Conversion of integral garage to playroom, demolition of porch, construction of single storey extension to front to provide cloakroom, carport and store
6A Limmard Way Bognor Regis

Thank you for your internet representation made on 3rd January 2013 which has been recorded as '**an objection**' with the comments as follows:

PROPOSED GROUND FLOOR PLAN

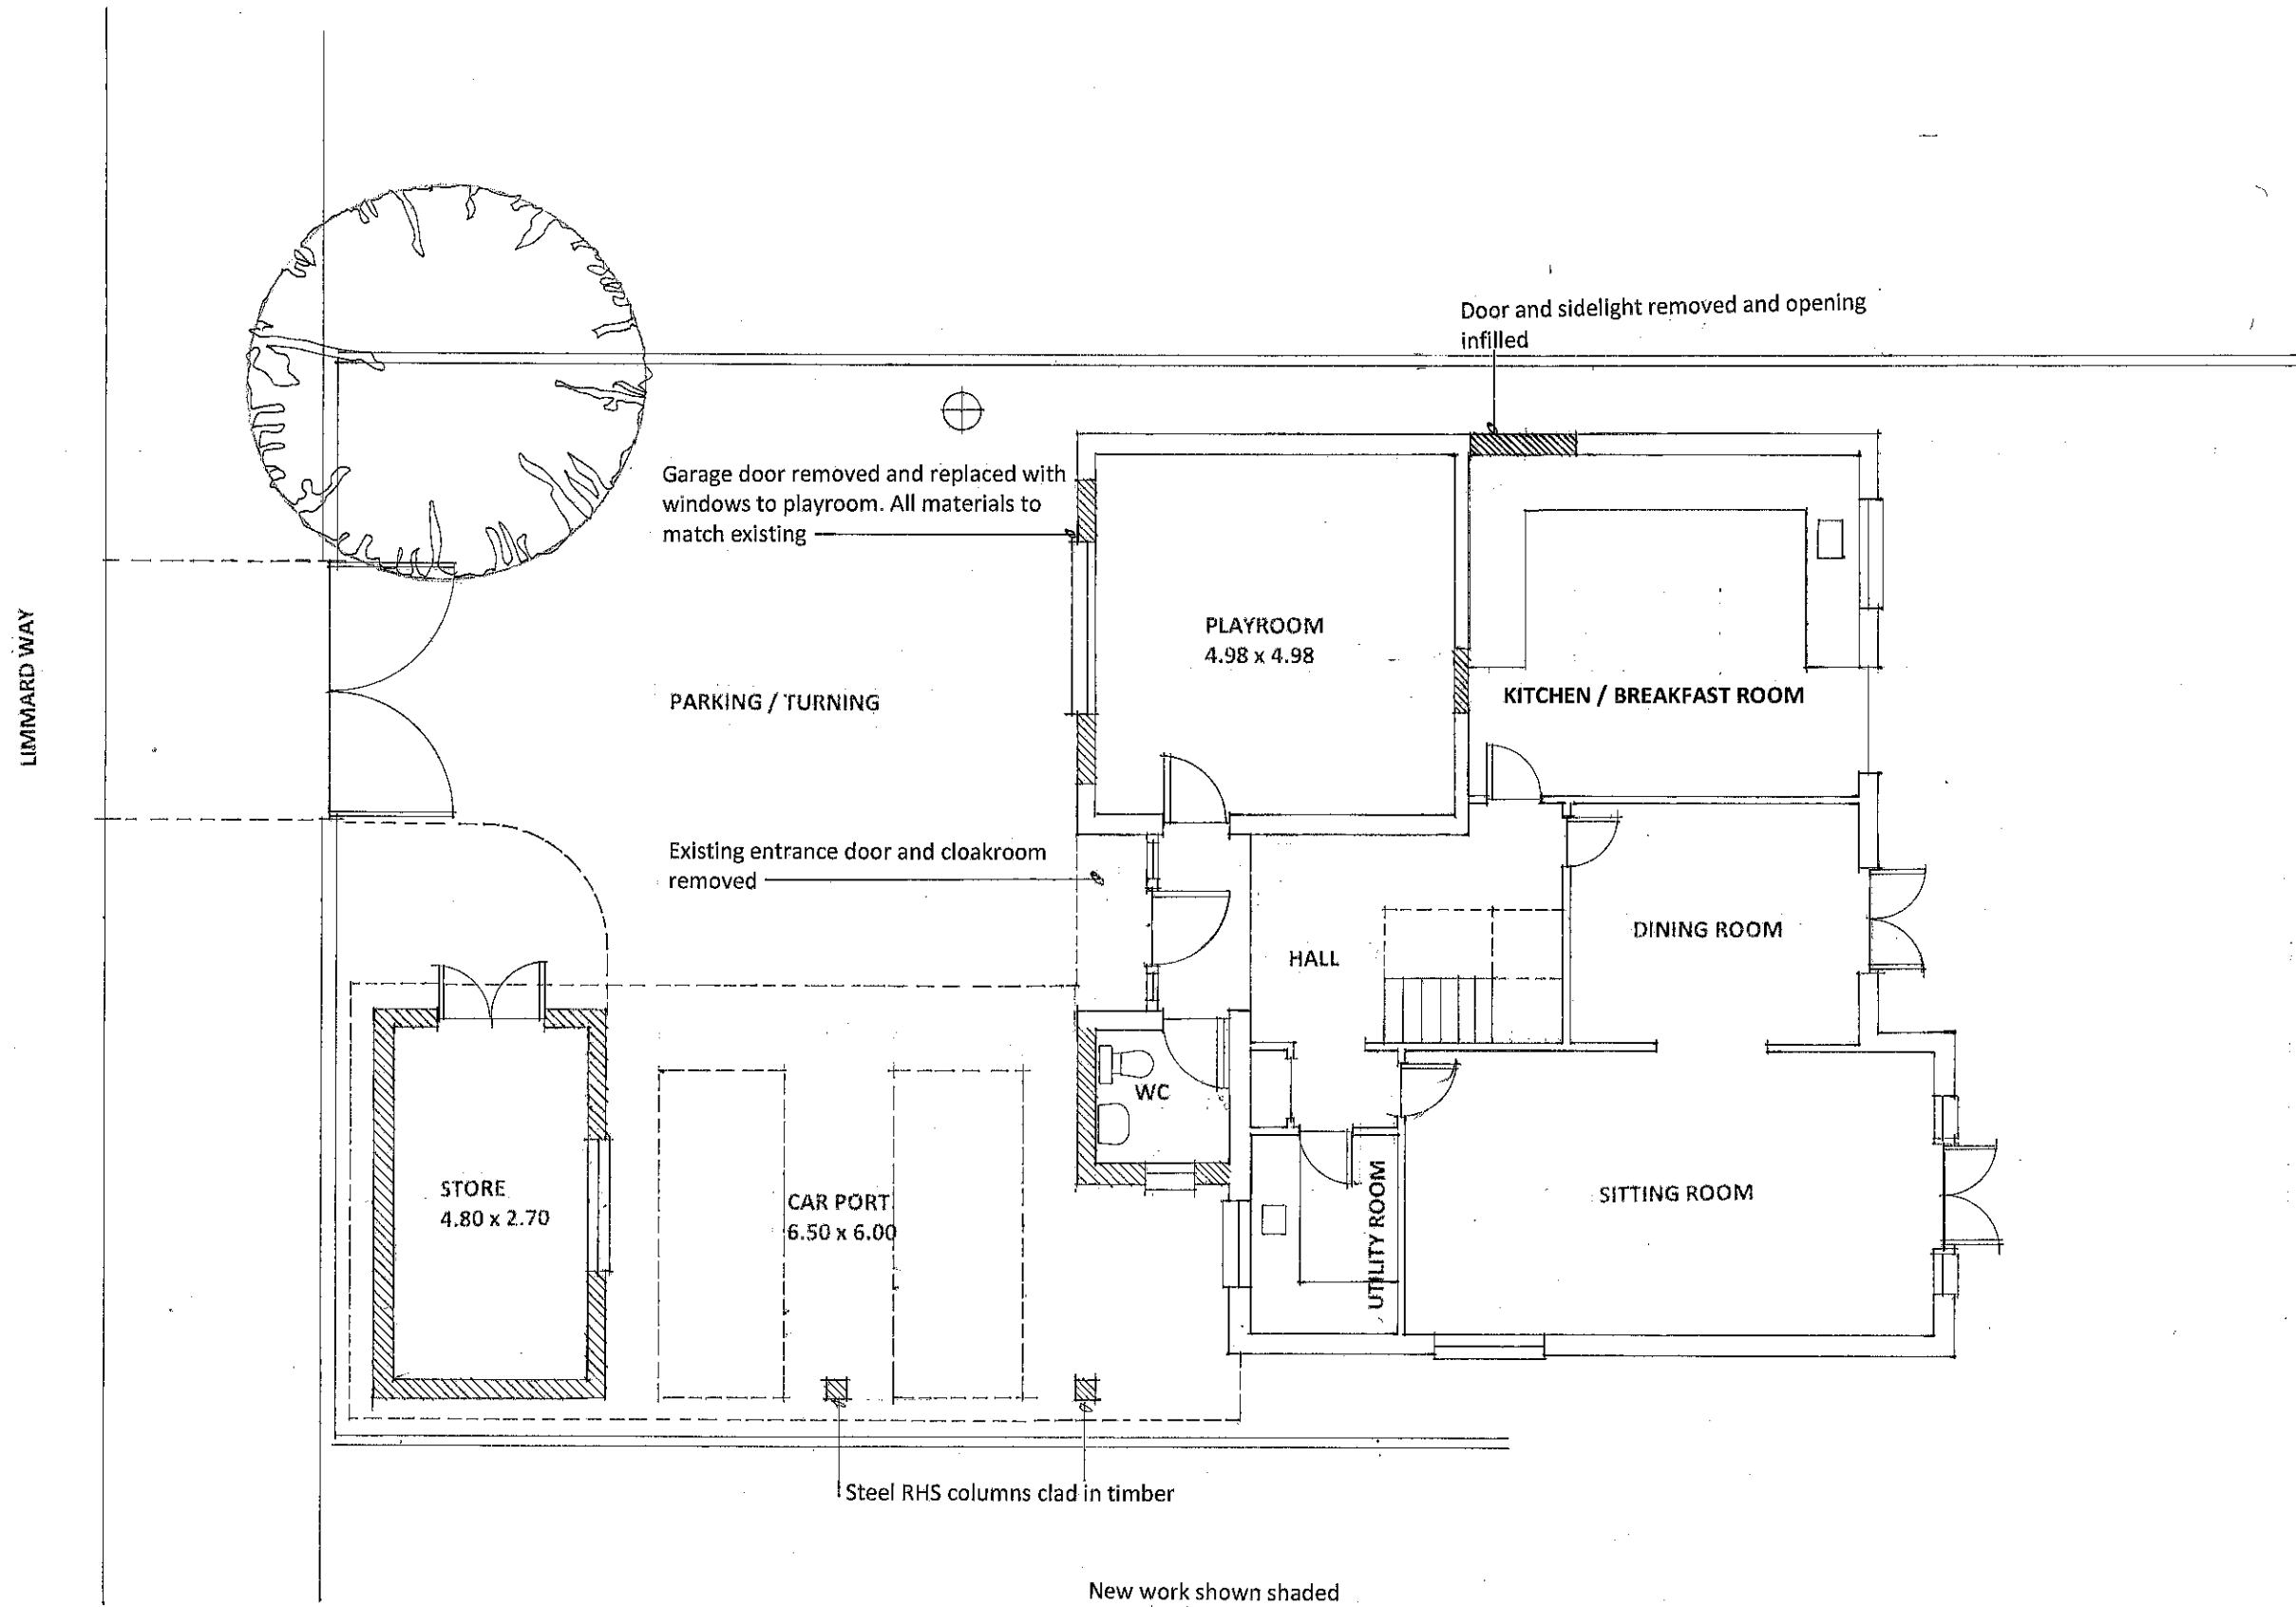
The proposed single storey "store" at the front is out of keeping with the current street scene and would detract from the current style of the way Summerley Estate is current planned and laid out..
